Date: 14 July 2026

Below are the comments of Derbyshire County Council in response to the application for non-material changes relating to Oaklands Farm Solar, EN010122.

Figure 4.11: Indicative Access Track  
Cross Sections (4.5m/6m/3.5m)

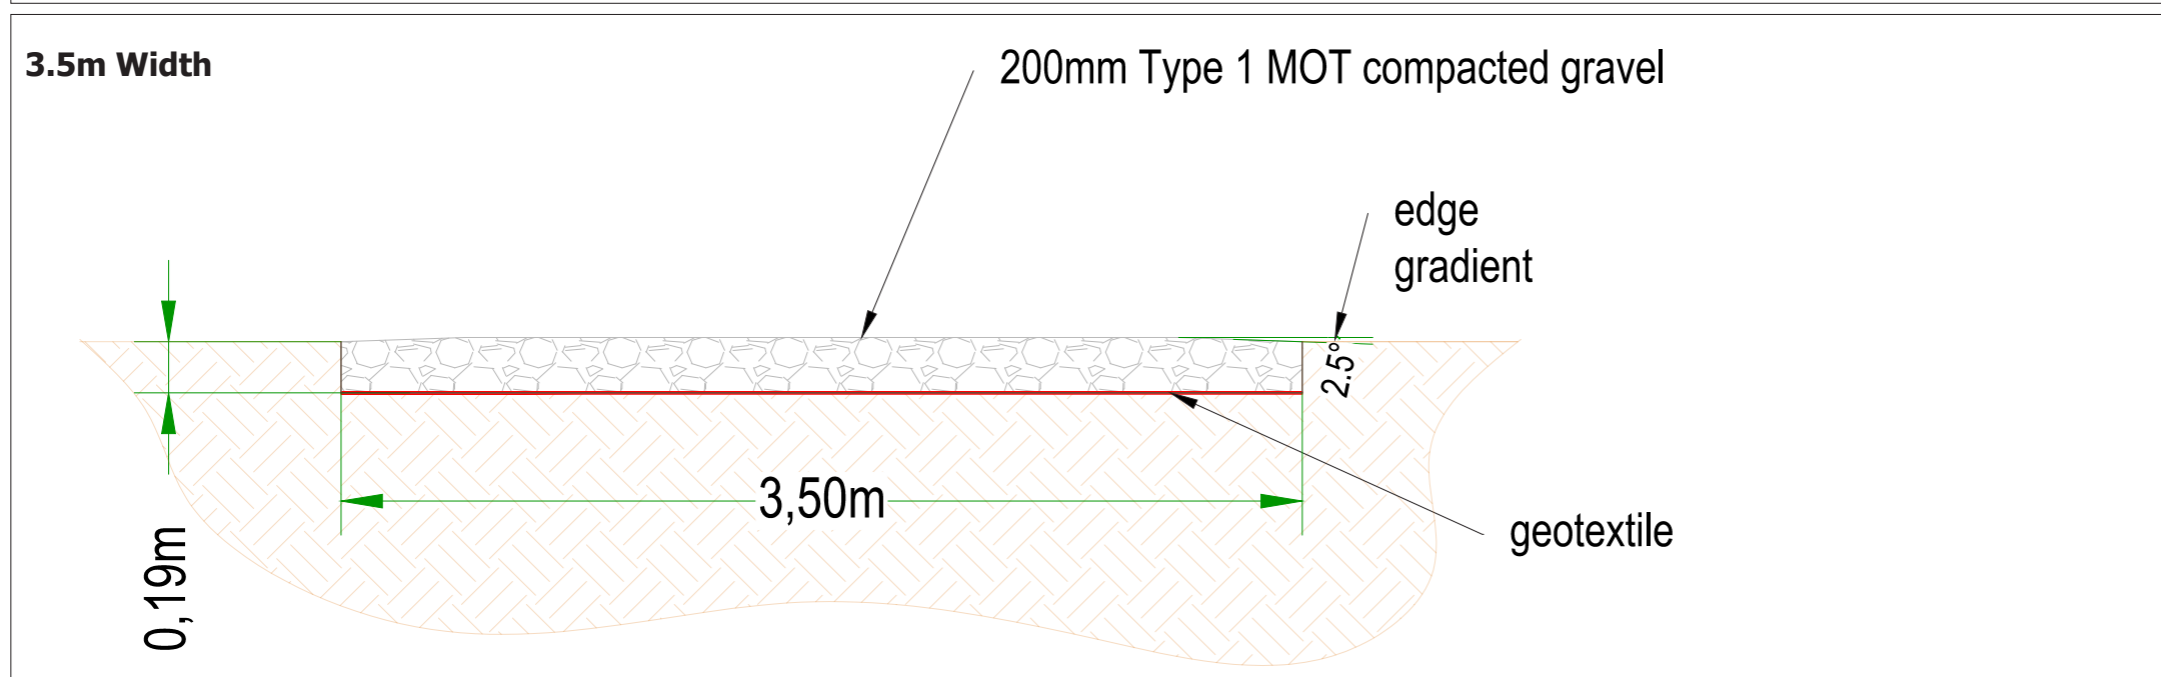
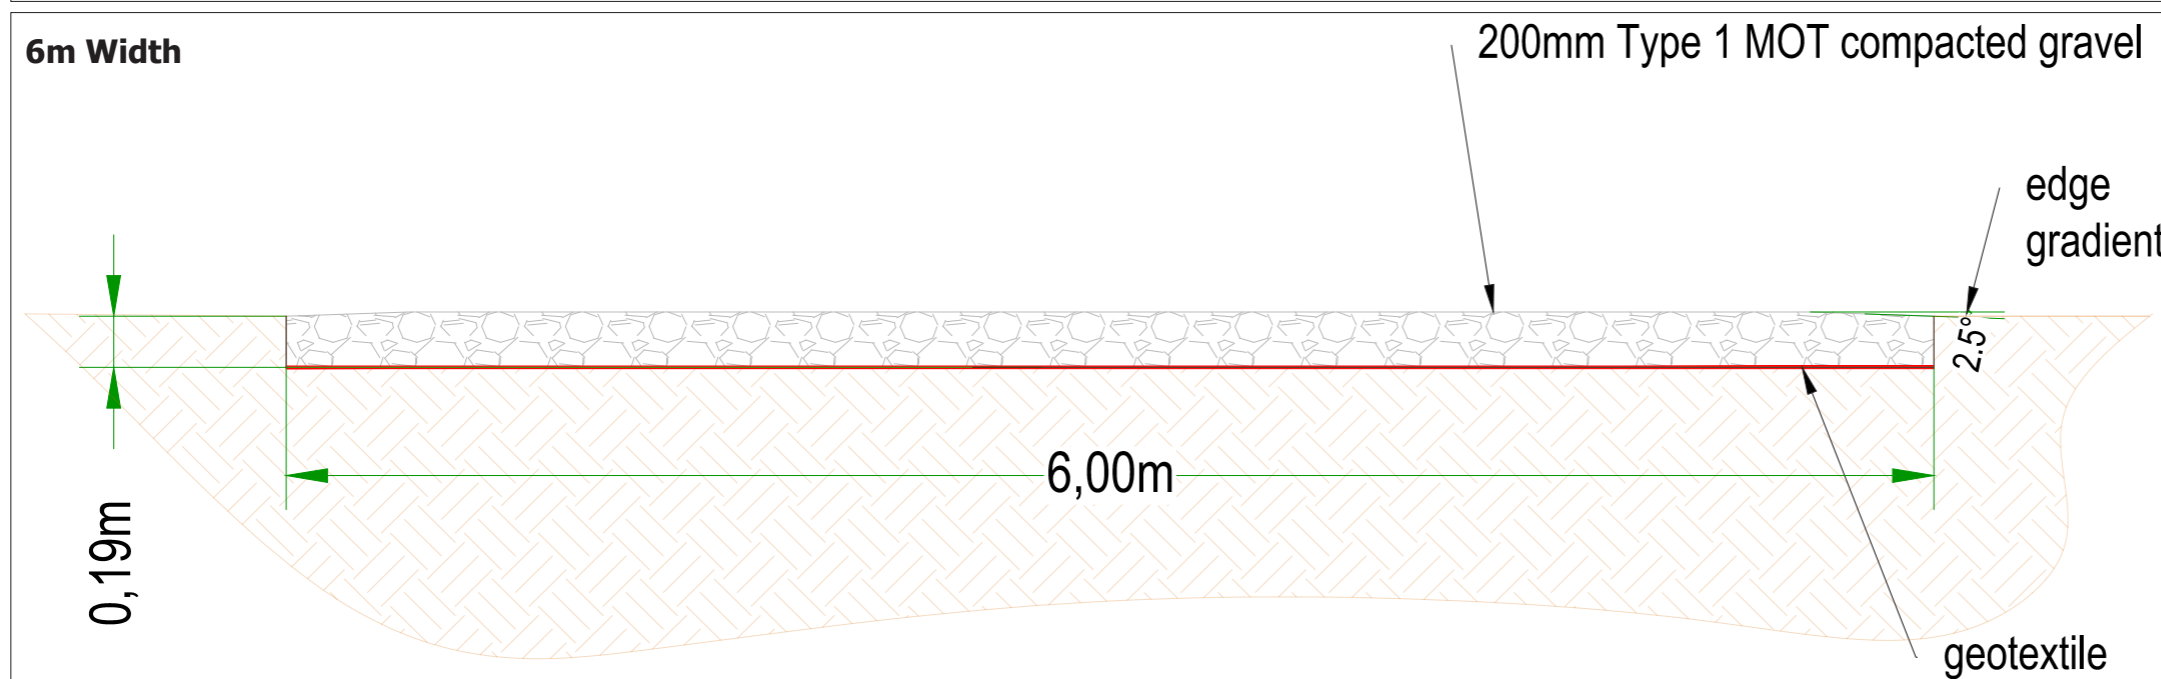
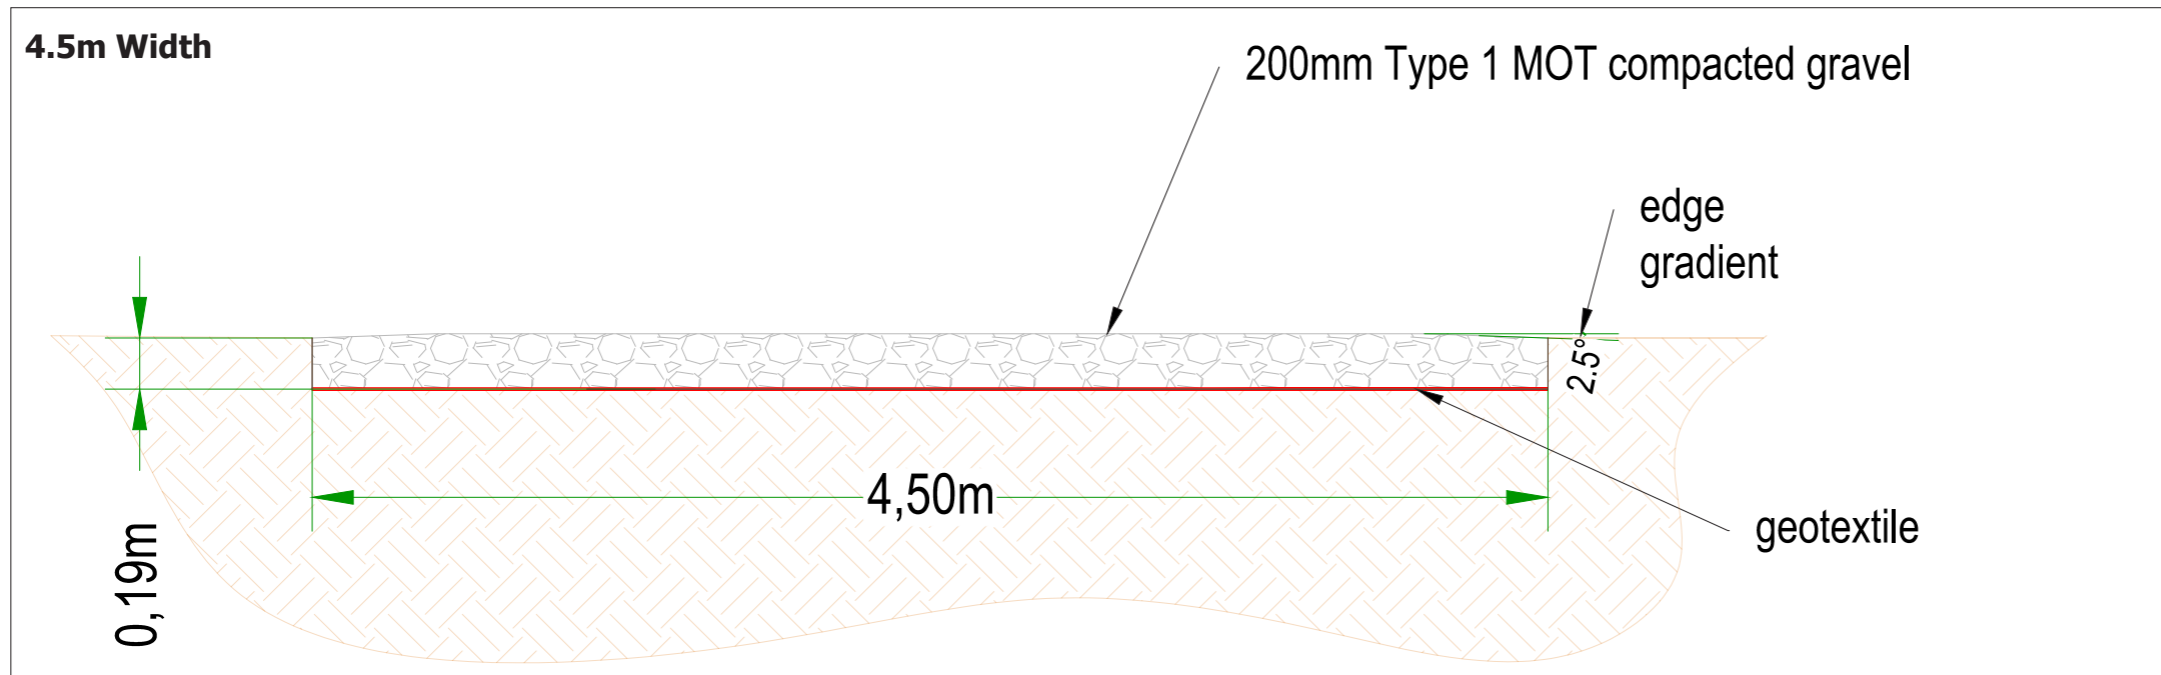
Change 7 – Permanent Internal Access Tracks - Currently the parameters allow for a permanent access track of 3.5 – 6.0m wide made up of 200mm of type 1 compacted stone/gravel with a geotextile membrane, or mown grass corridor. It is now proposed that this is amended to allow up to 400mm of compacted stone/gravel, such as type 1/6F5, with a geotextile membrane, or mown grass corridor. It should be noted that the additional 200mm of the material would be used to build up the road as opposed to requiring further excavation.

An additional 200mm of material to build up the access track above ground level may affect visual impact, potentially land drainage and surface water flows, along with site restoration upon decommissioning. The importation of the additional material must also be considered in the Construction Traffic Management Plan as the site, in association with other local, annual events, and ongoing highway and bridge works, has a cumulative impact on local domestic and commercial traffic flows. This issue was discussed at length at the examination and is of considerable concern to local residents and businesses.
